# CITY OF PORTLAND BUILDING PERMIT

210 VALLEY ST

**PERMIT ID:** 2012-65554

has permission to **Buildout basement - Adding two bedrooms**

**UNIT 1 additional 2 rooms in basement**

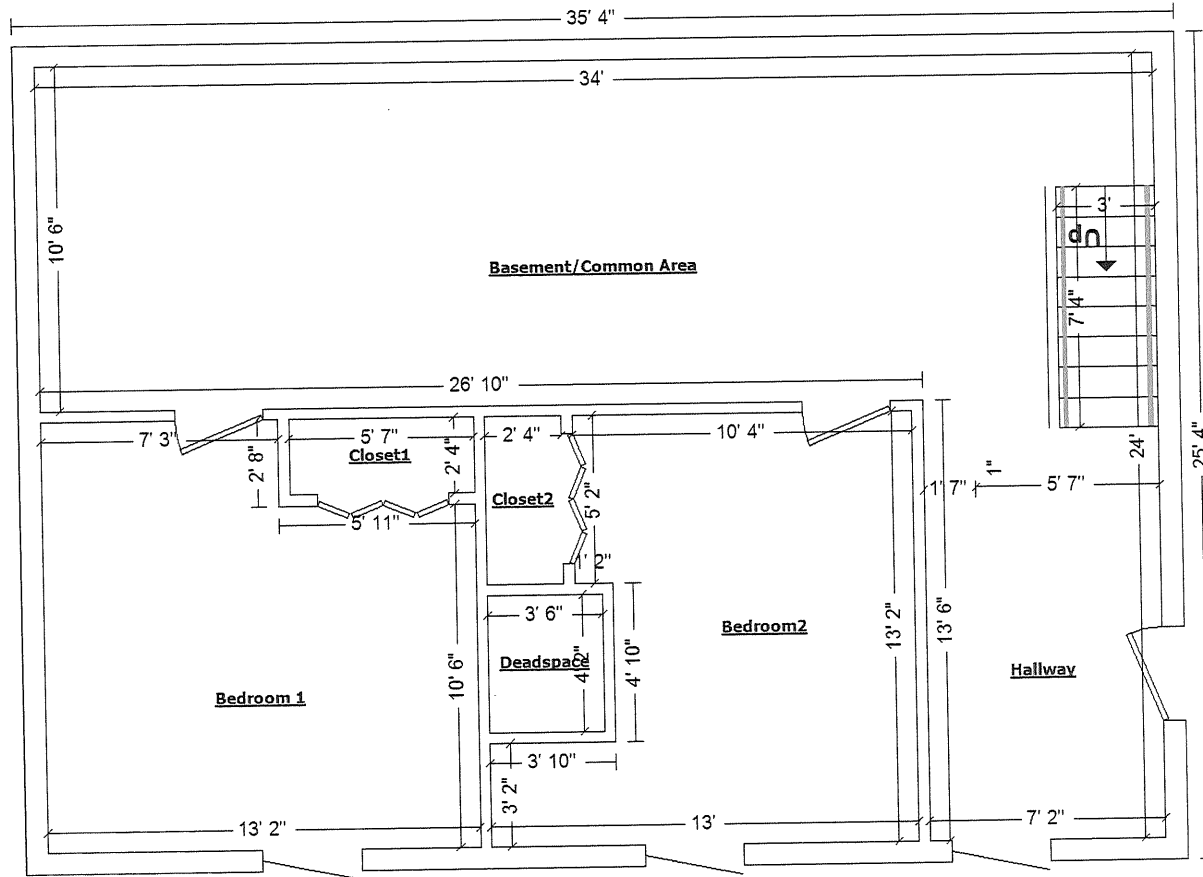
Prior to building permit issuance, our office needs a cross section of the typical wall detail, columns, and concrete work. Below are items that need to be identified on the plan.

- What is the proposed finish headroom of the basement?
- What is the basement ceiling constructed with?
- How is this space separated from the second unit?
- What is the rise/run and headroom for the interior stairwell?
- Is the egress casements window well(s)? What is the finish height from grade?
- Where are the doors for each proposed bedroom located?
- What is the "Deadspace" build-out in bedroom 2?
- Ventilation of this space is required per ASRAE 62.2 , 2007 edition. Insulation shall comply with the IECC, 2009 (Maine State Energy Codes).

- What is the proposed finish headroom of the basement? **7'11**
- What is the basement ceiling constructed with? **Open floor joist TBD by homeowner Possible drop ceiling, not contracted**
- How is this space separated from the second unit? **The 1<sup>st</sup> and second units are separated by a stairwell and separate entrances. These are areas that we have not been contracted to work on.**
- What is the rise/run and headroom for the interior stairwell? **We are not changing stairs or**

- Is the egress casements window well(s)? What is the finish height from grade? Low E Vinyl Casement windows RO 31.75 x 54.75 per Harvey Building quote supplied. Sill heights are 38" from floor grade.
- Where are the doors for each proposed bedroom located? **Corrected drawing submitted**
- What is the "Deadspace" build-out in bedroom 2? **There is a non-working chimney in the basement**
- Ventilation of this space is required per ASRAE 62.2 , 2007 edition. Insulation shall comply with the IECC, 2009 (Maine State Energy Codes). **Submitting quote from Casco Bay Insulation. The exterior walls will be studded out with 2x6 PT framework. There will be a variance of 1 to 3 inches of foam sealing stud work to exterior walls and a minimum of 1 inch spray foam between studs. The bays will have added R21 to both meet and exceed current code requirements.**
